Our Ref: E3084-JML20-060068

E3084: Sandstone Precinct, Education Building
Subcontract No: 200996-D&C-011
Changes to MOD 9

As advised by Built, changes to the MOD 9 have occurred which will be incorporated into the latest design. The following list highlights those changes which are Architectural or Building Performance requirements that will require the External Façade works provided by JMLC to be adjusted to suit.

01
-
1:200
EDUCATION BUILDING - PROPOSED NORTH ELEVATION

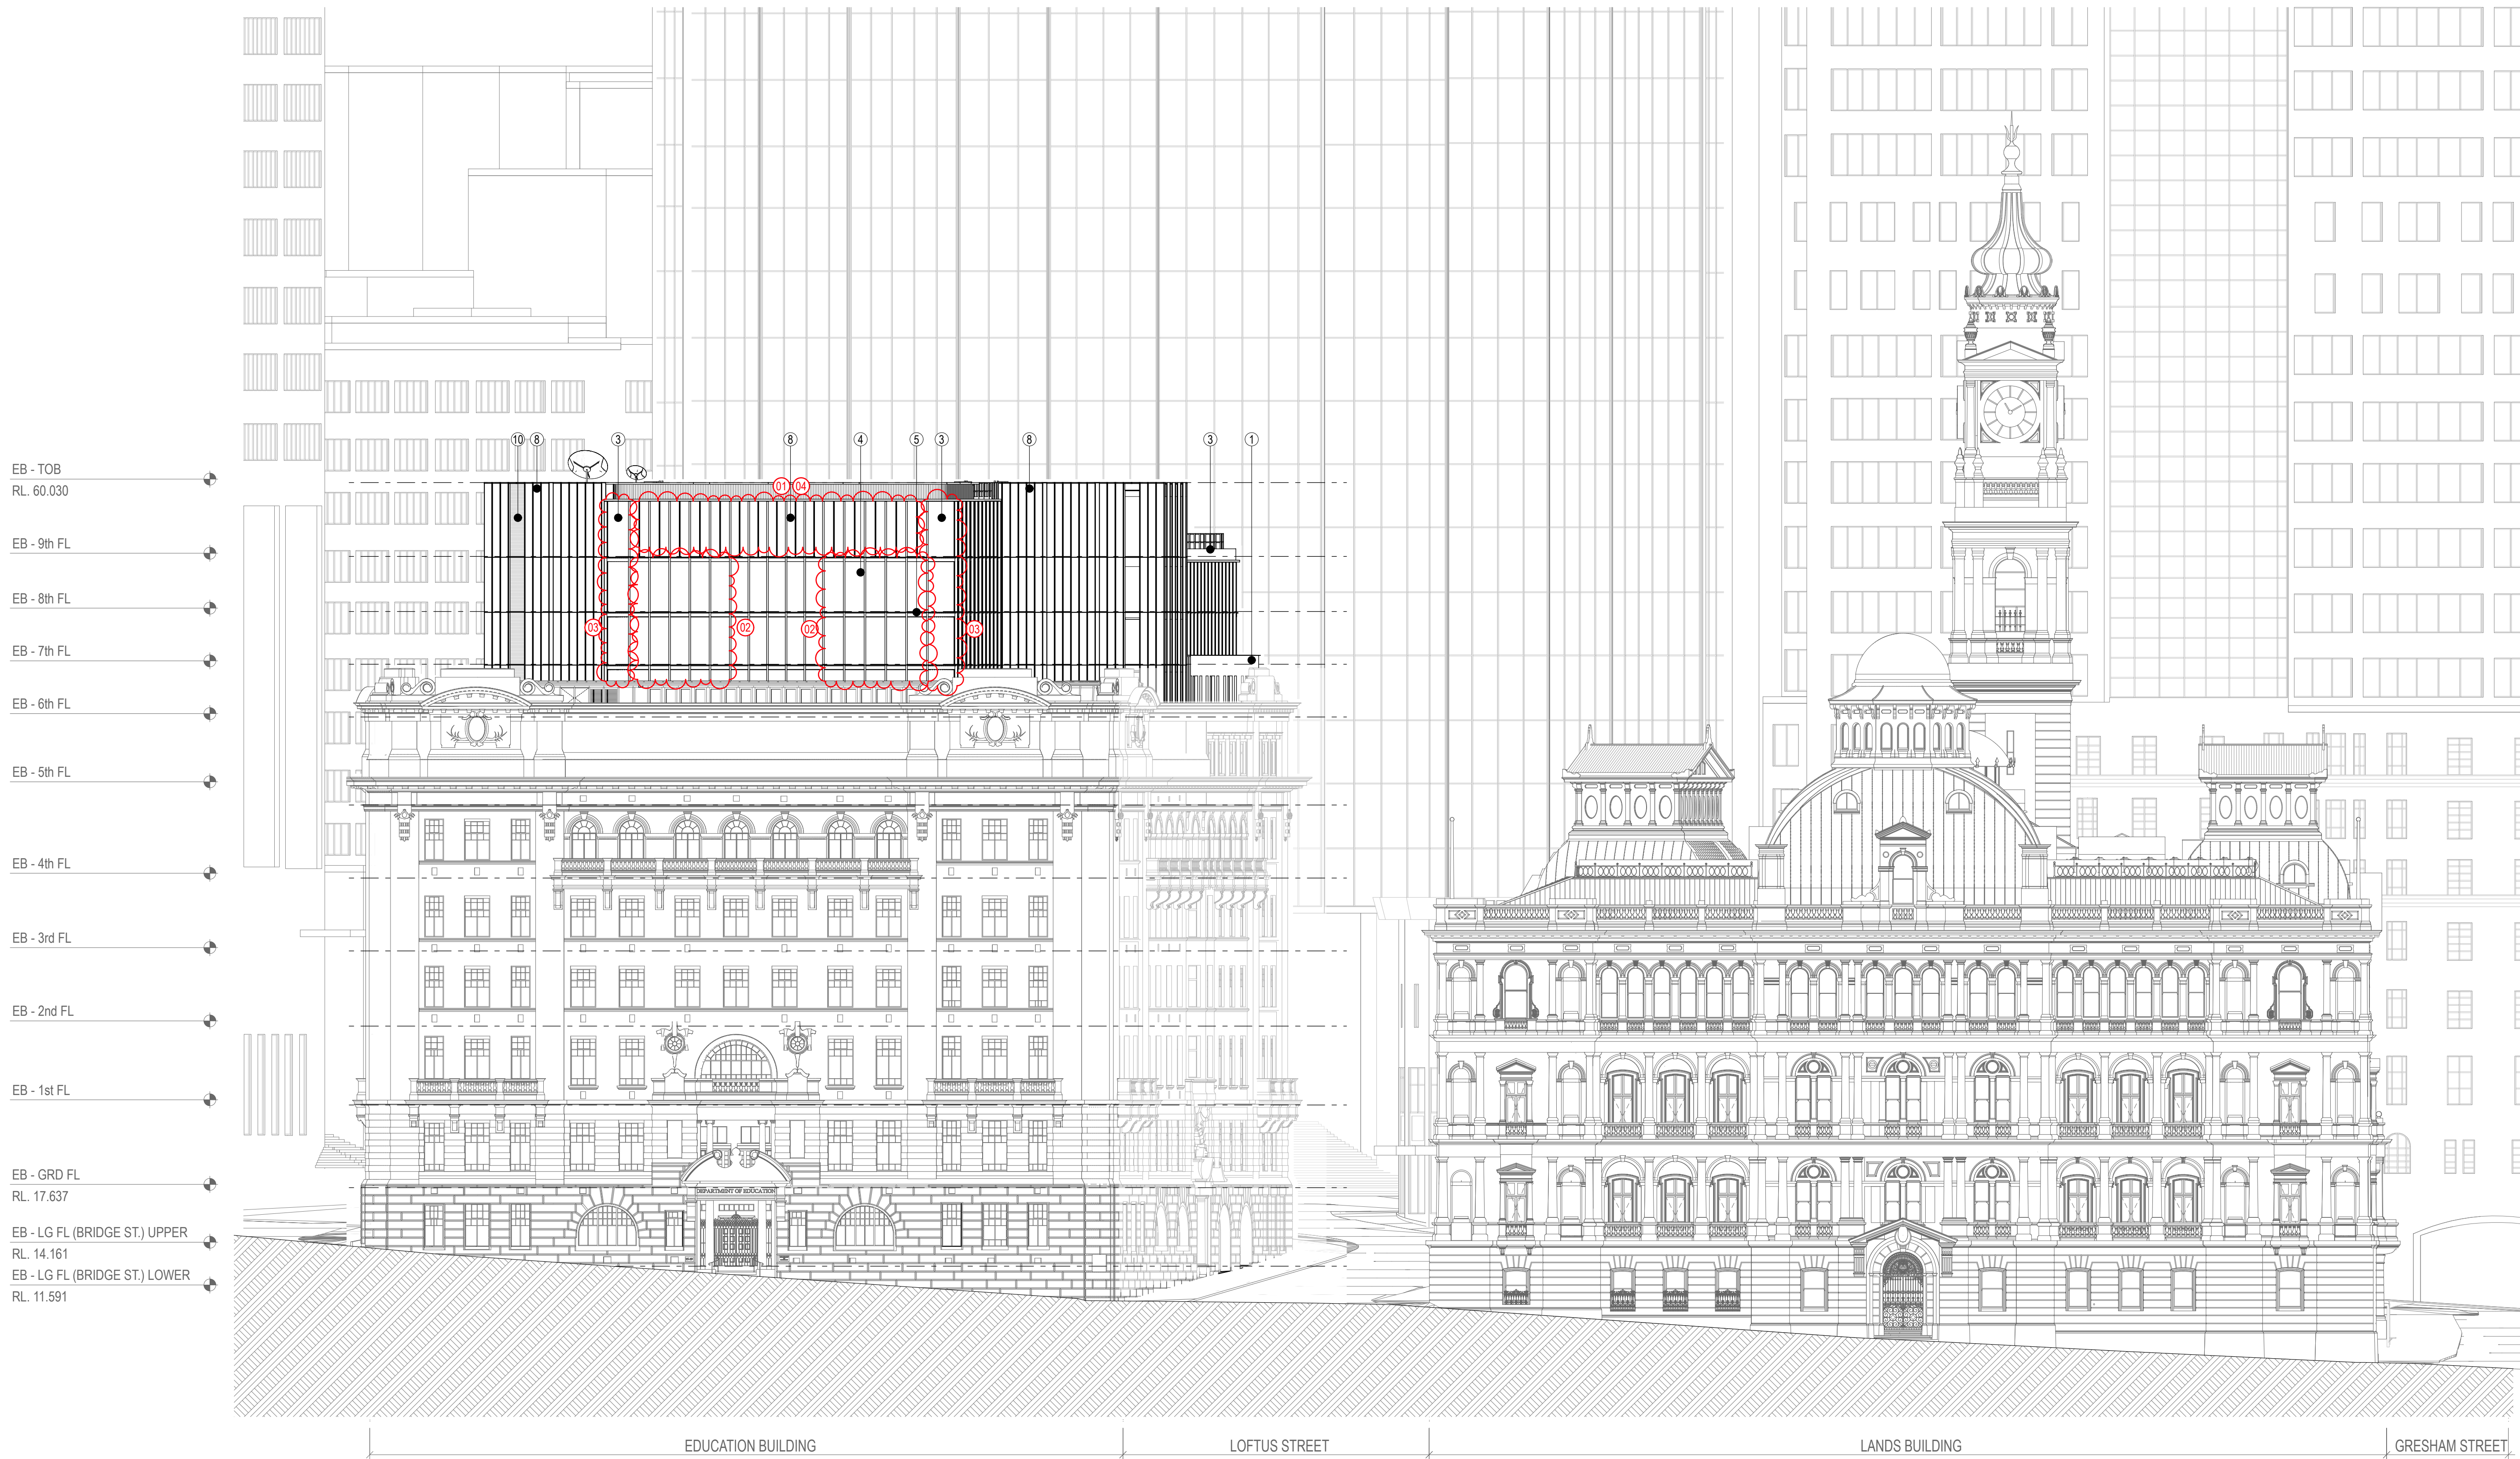
8. The Northern external face of the façade (FTE11) has changed from fluted perforated cladding to fluted solid cladding, as the plant room does not require the North side to be perforated for air flow.

12. The radius of the all curved glass and cladding to the internal courtyard (FTE03) and all external façade (FTE08 & FTE11) has changed to 1500mm, as the previous glass radius could not physically be made with the low e coating by any supplier/manufacturer globally. This has also forced the mullion set out to change in these areas, with the mullions around each curved glass corner shuffling slightly with minimal visual impact to fit the new glass size.

01 EDUCATION BUILDING - PROPOSED EAST ELEVATION
1:200

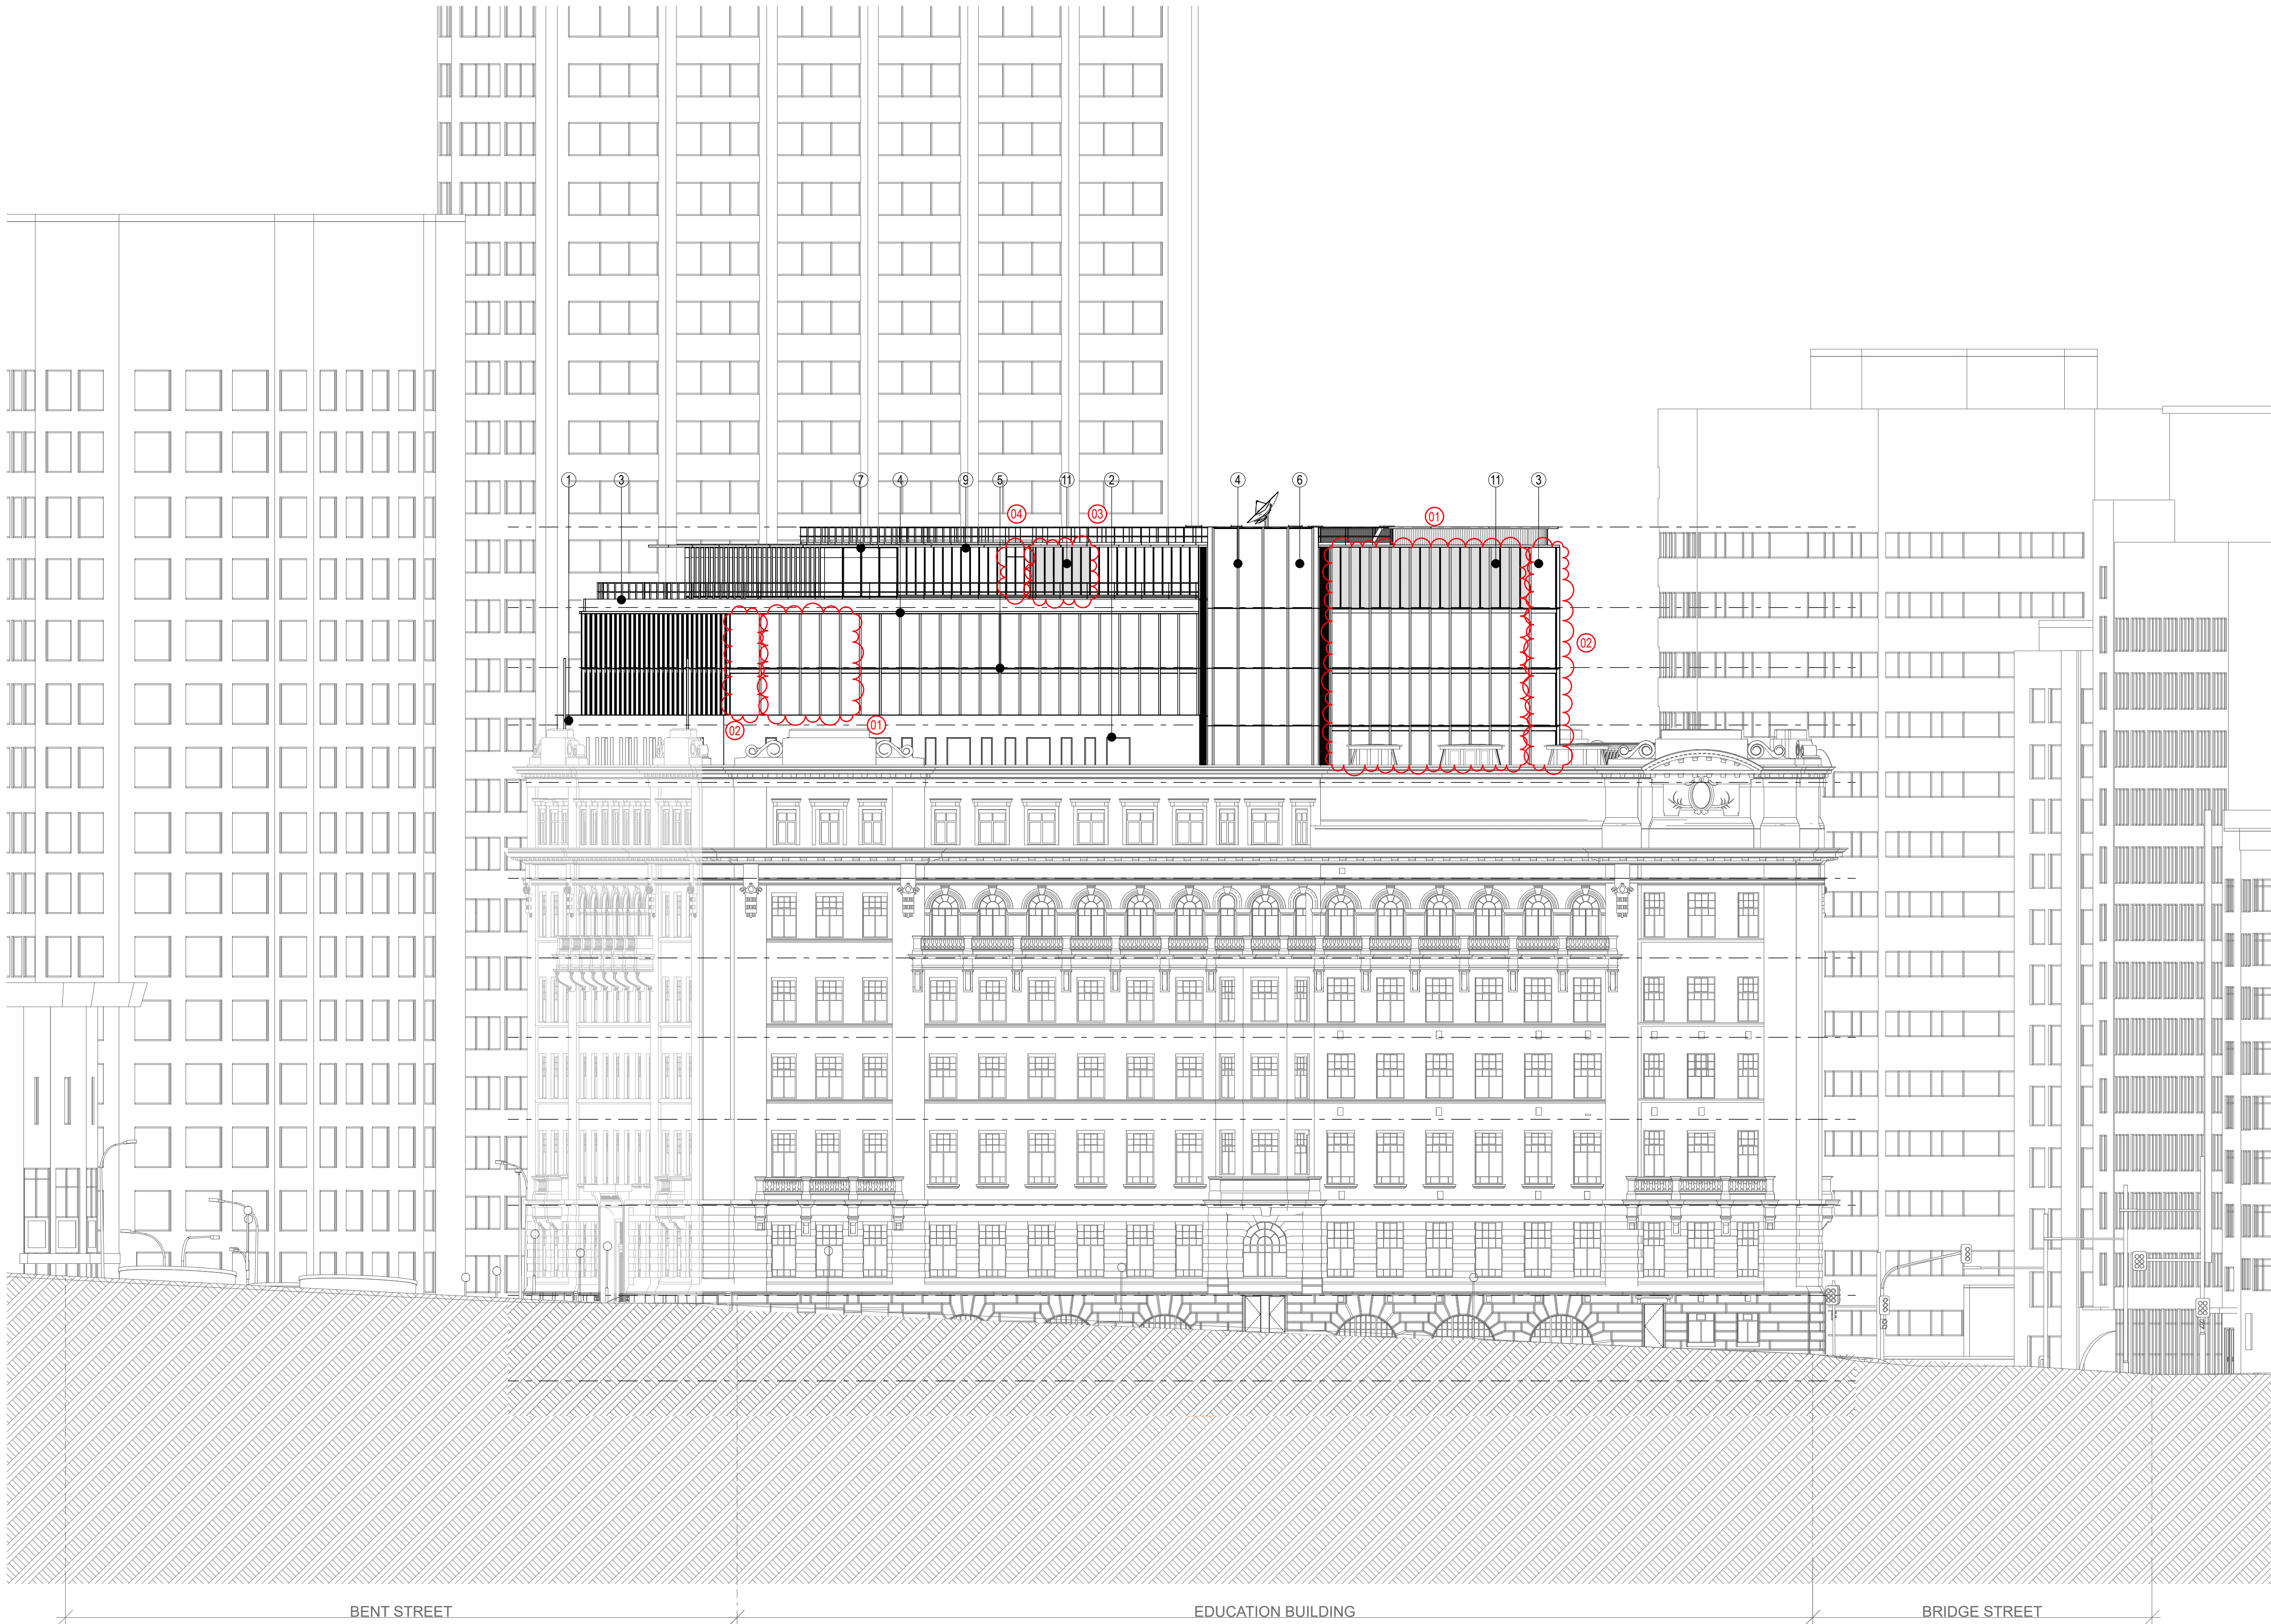
9. The plant room door on level 9 of the external Eastern elevation of the façade (FTE10) has been relocated a few panels South due to the internal room layout. The louvres have been relocated slightly North and are laid over 7 panels on their side. They are also covered by perforated fluted cladding to conceal the mechanical louvres and maintain the design intent.
